From: Russell McCourty [REDACTED]
Sent: 25 July 2017 12:22
To: Mark Jones
Cc: John Hinds
Subject: A/87/17/HH & A/88/17/L

Following comments from Ian Wightman, we have amended the main elevation as per the attached.

PROPOSED FLOOR PLANS 1:50

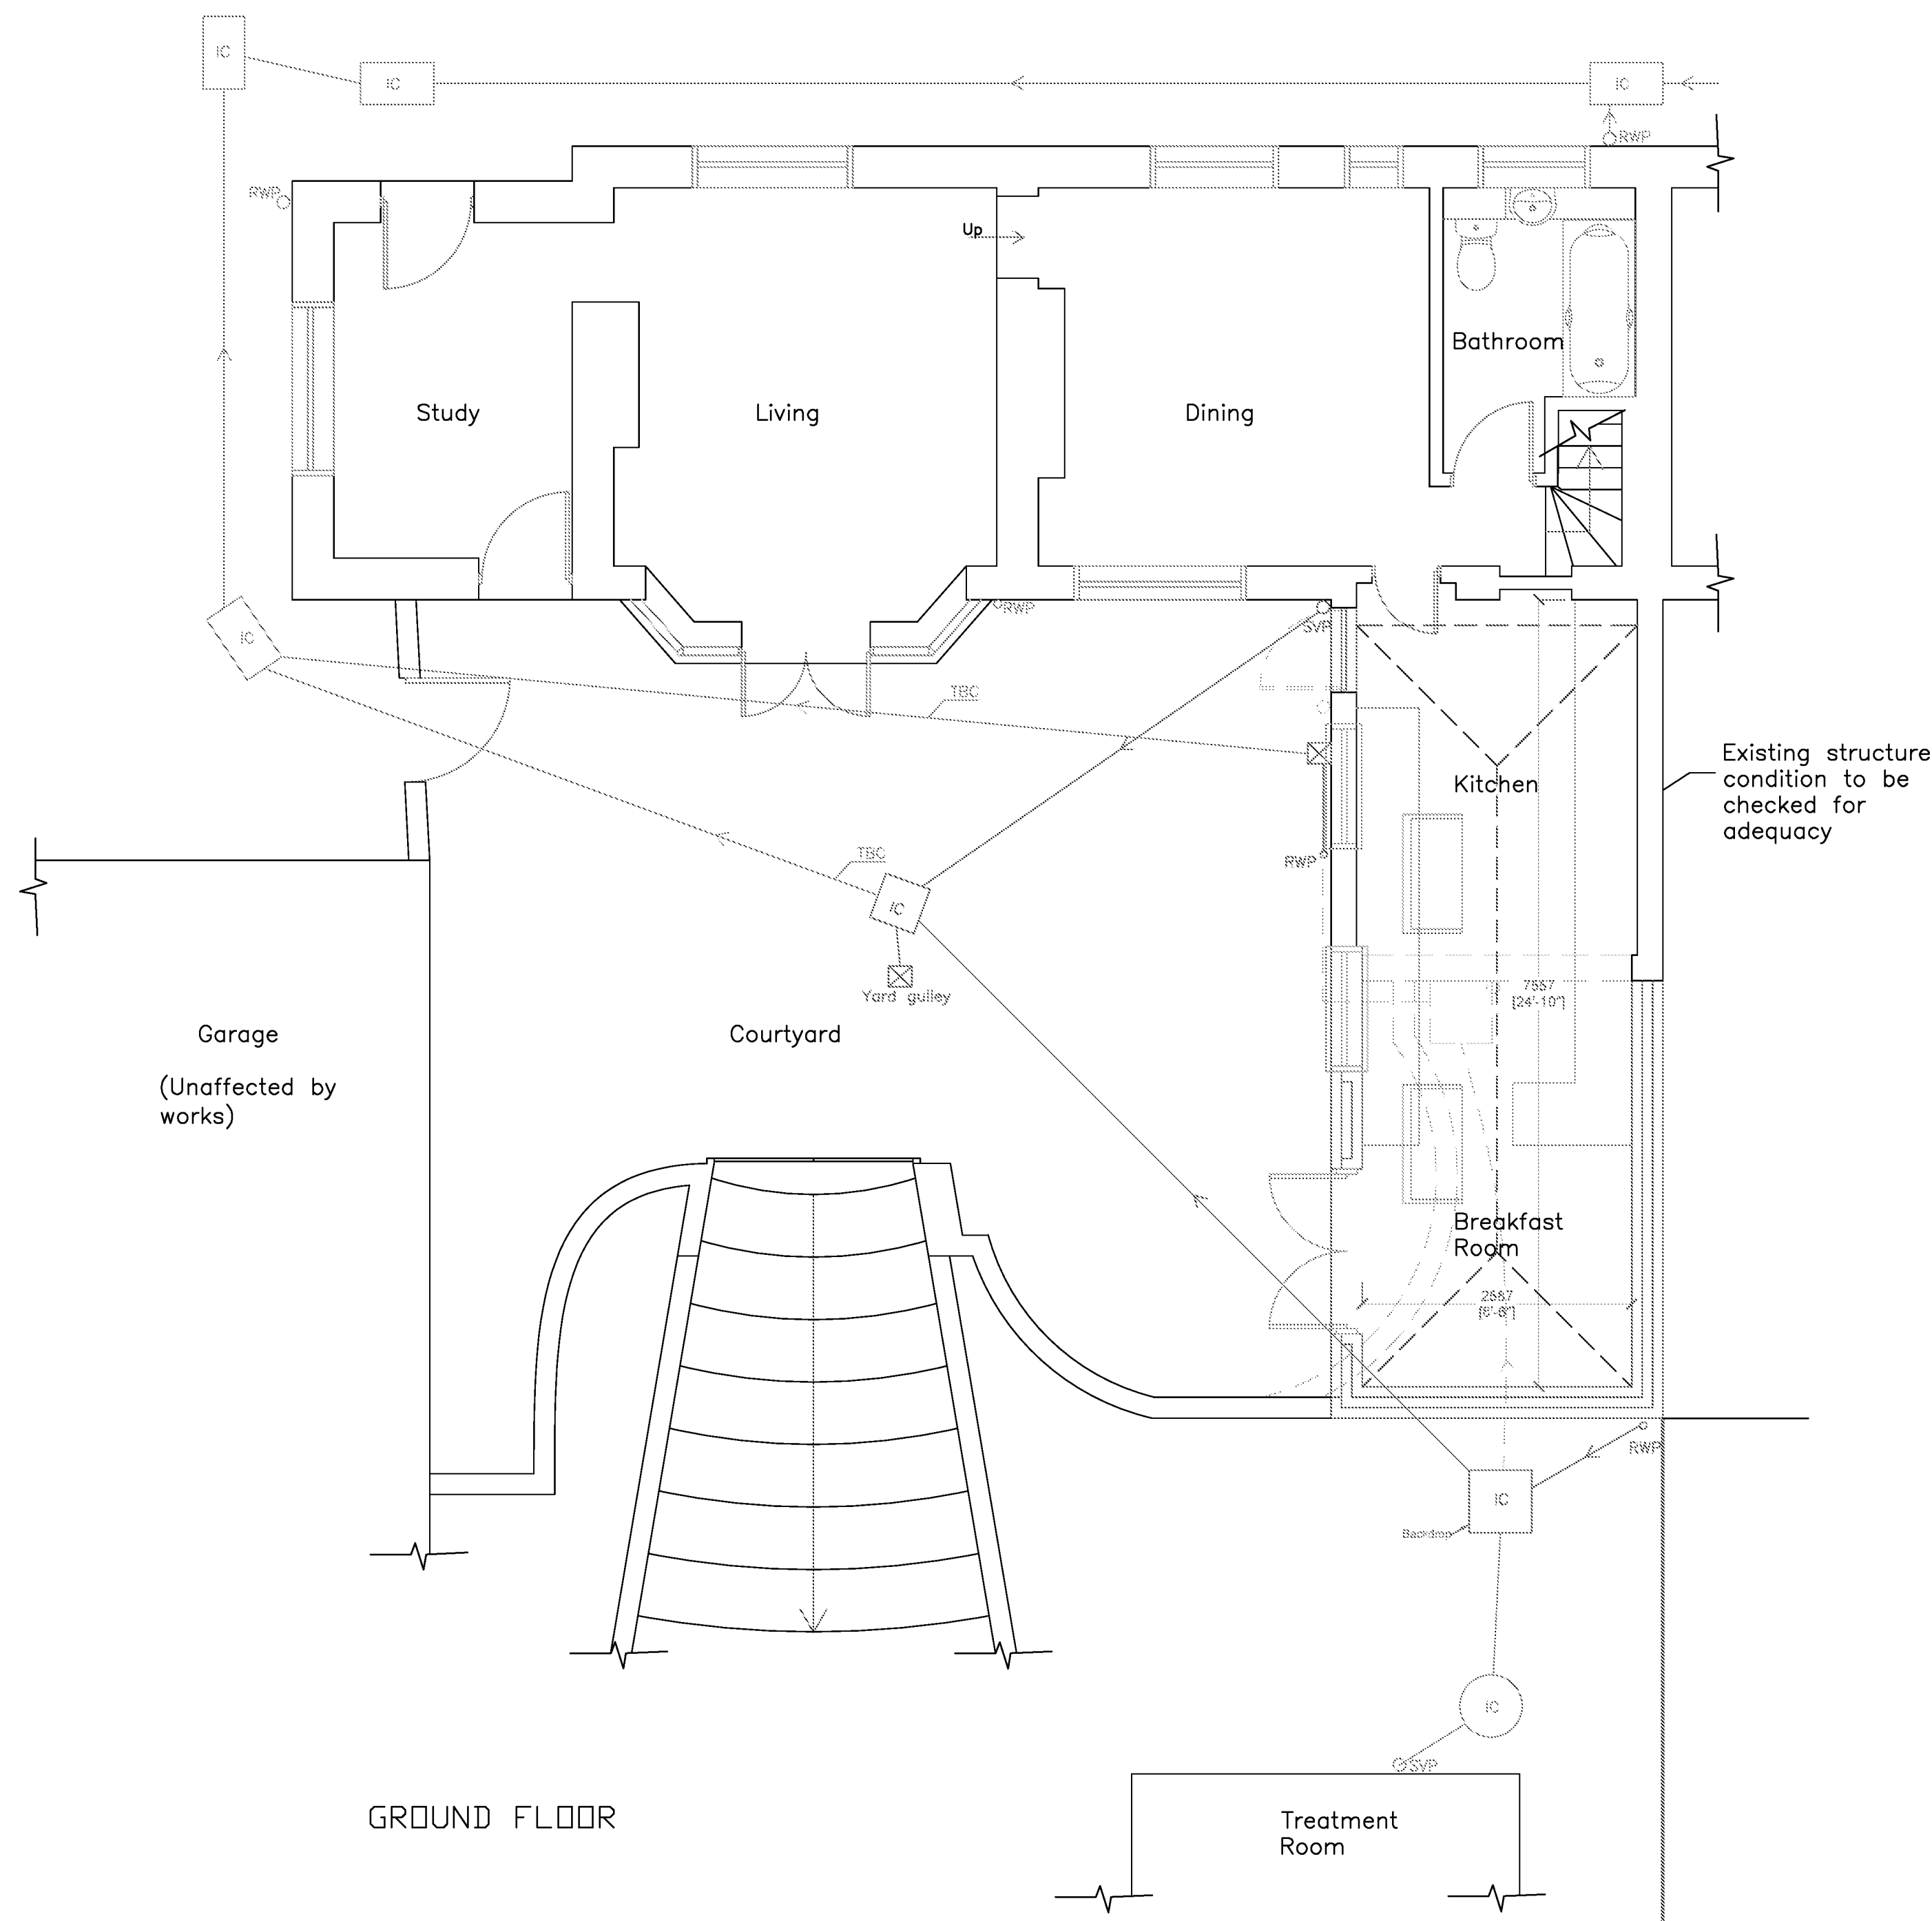
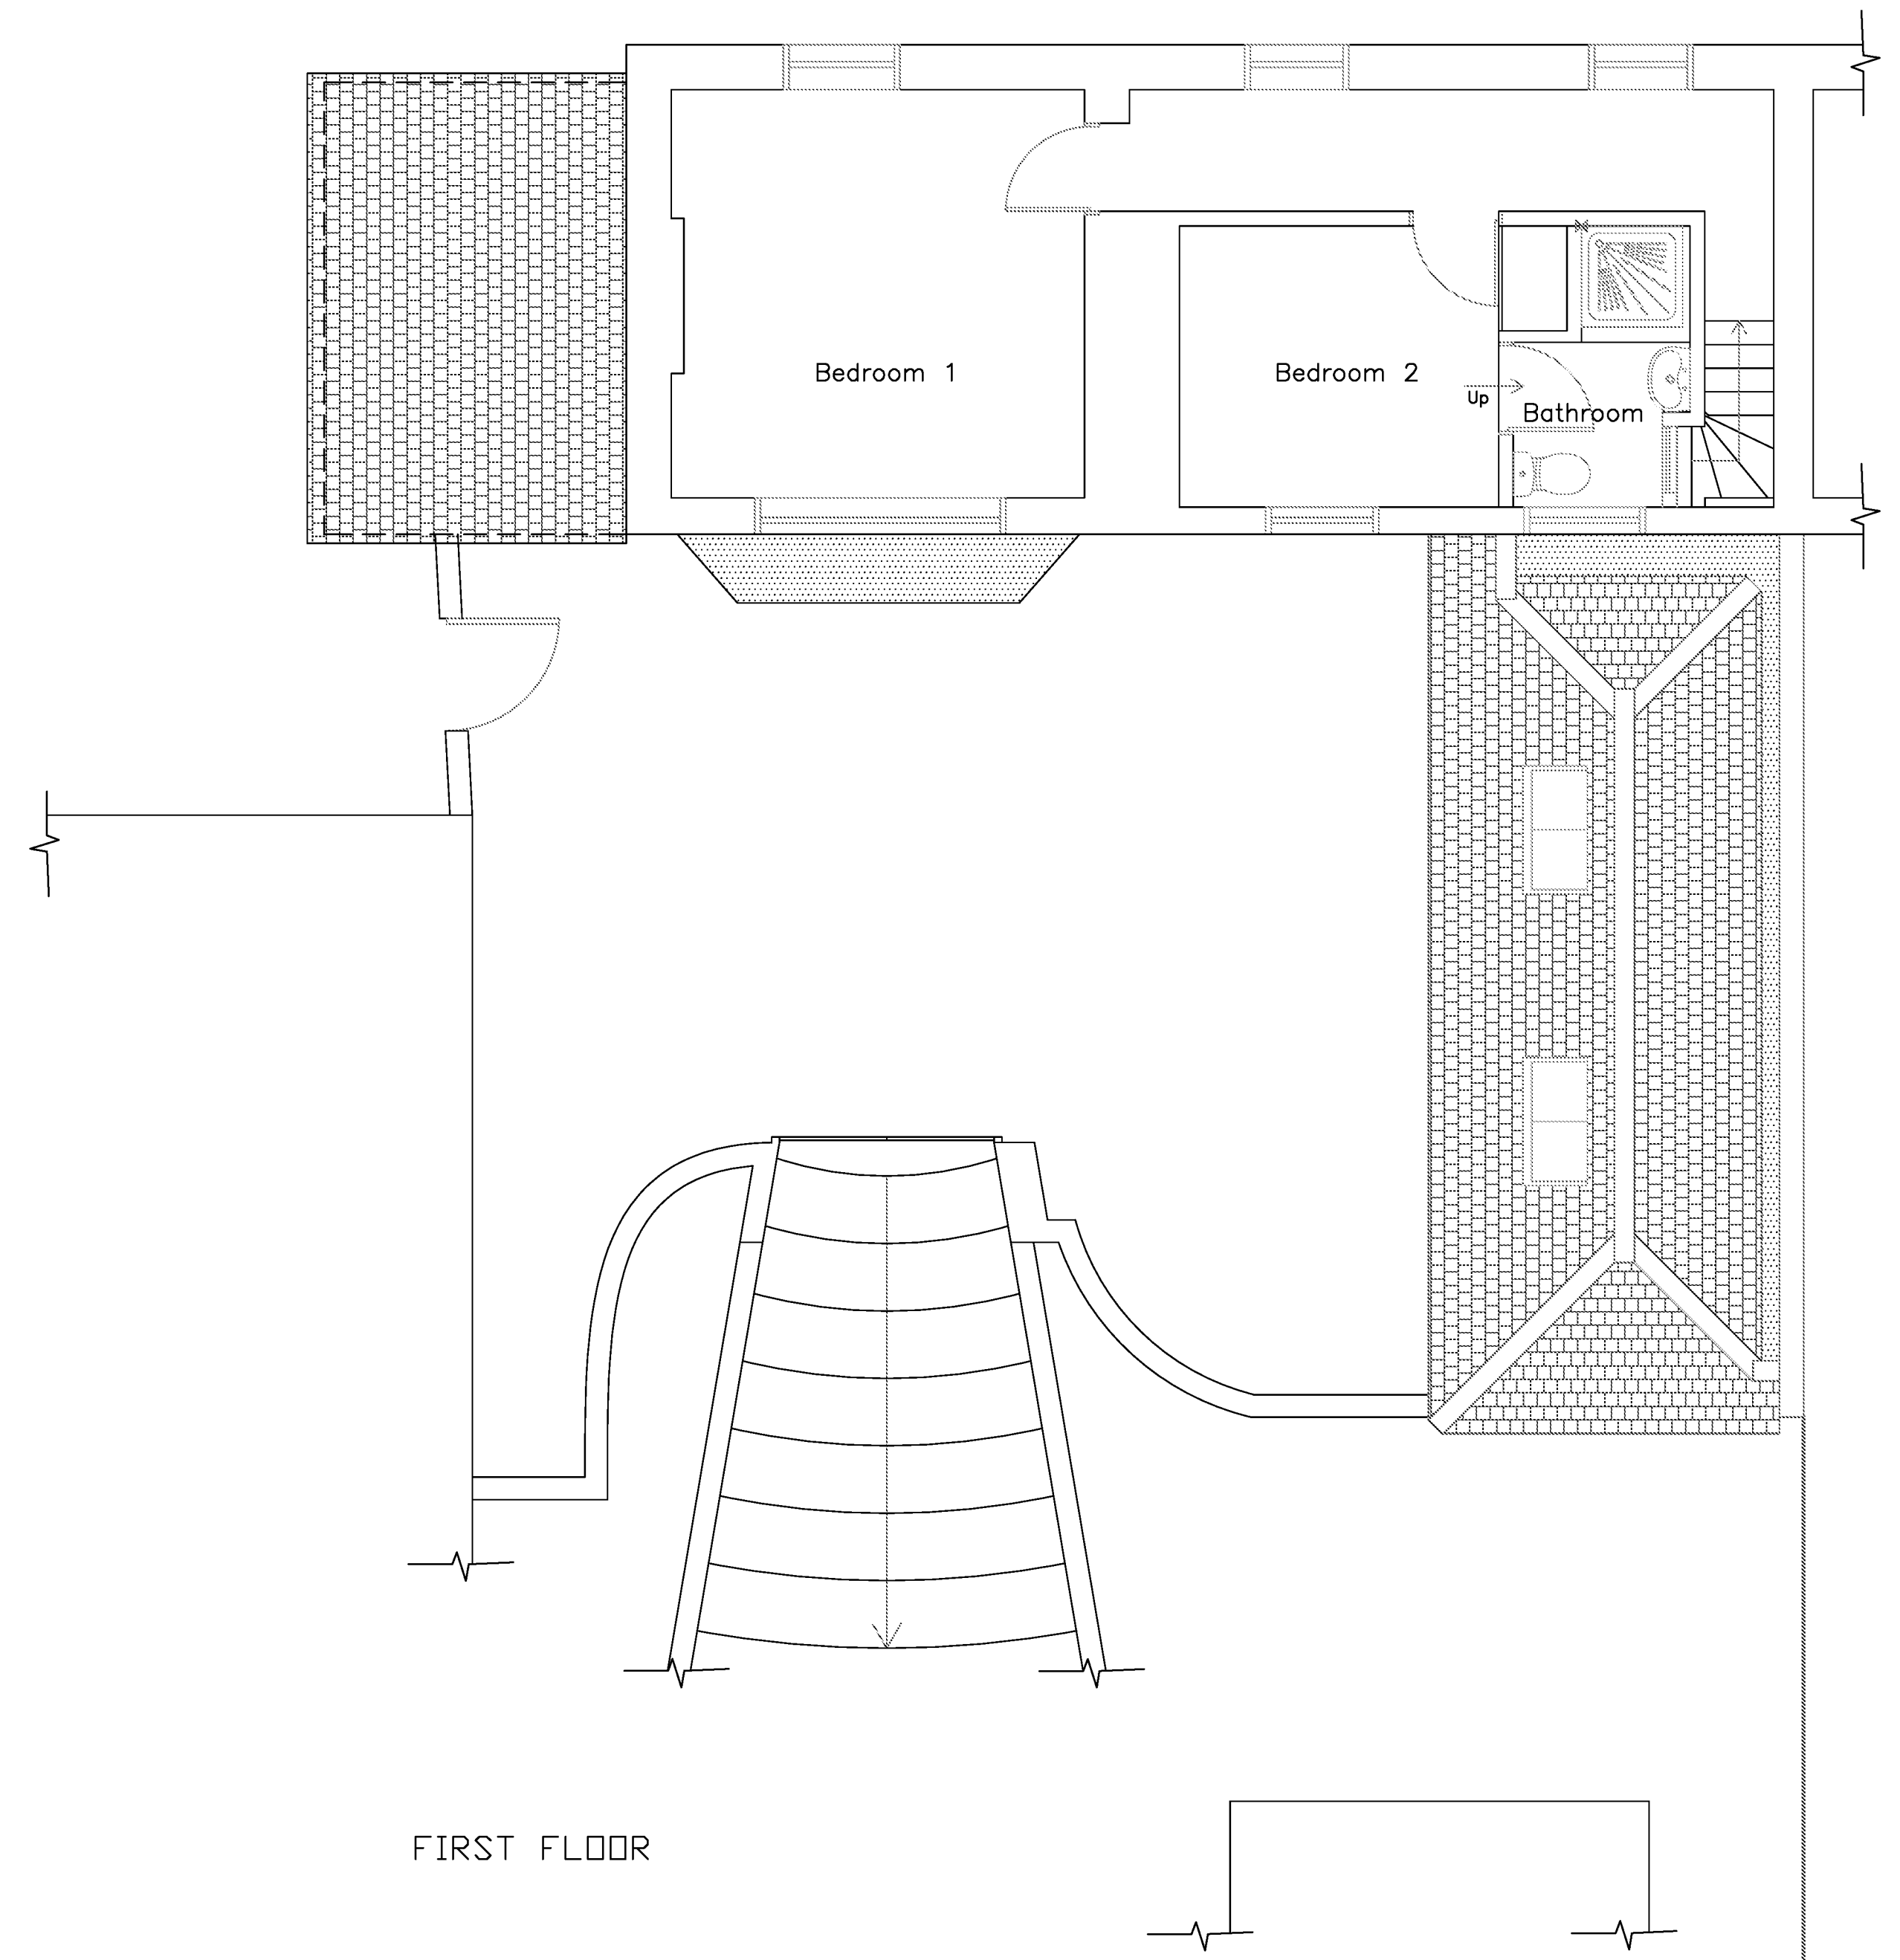
The main wall construction of the extension will be 215mm solid brick in English Bond pattern, tanked and internally insulated to bring it up to today's UK Building Regulations standard in accordance with Part L. This will make the external wall thickness approximately 290mm from outside of brick to inside of plaster.

Proposed windows and doors are to be hardwood, painted white and fitted with slim double-glazing (10-12mm). Window style to be in small panes as per the elevations (to match the existing main property).
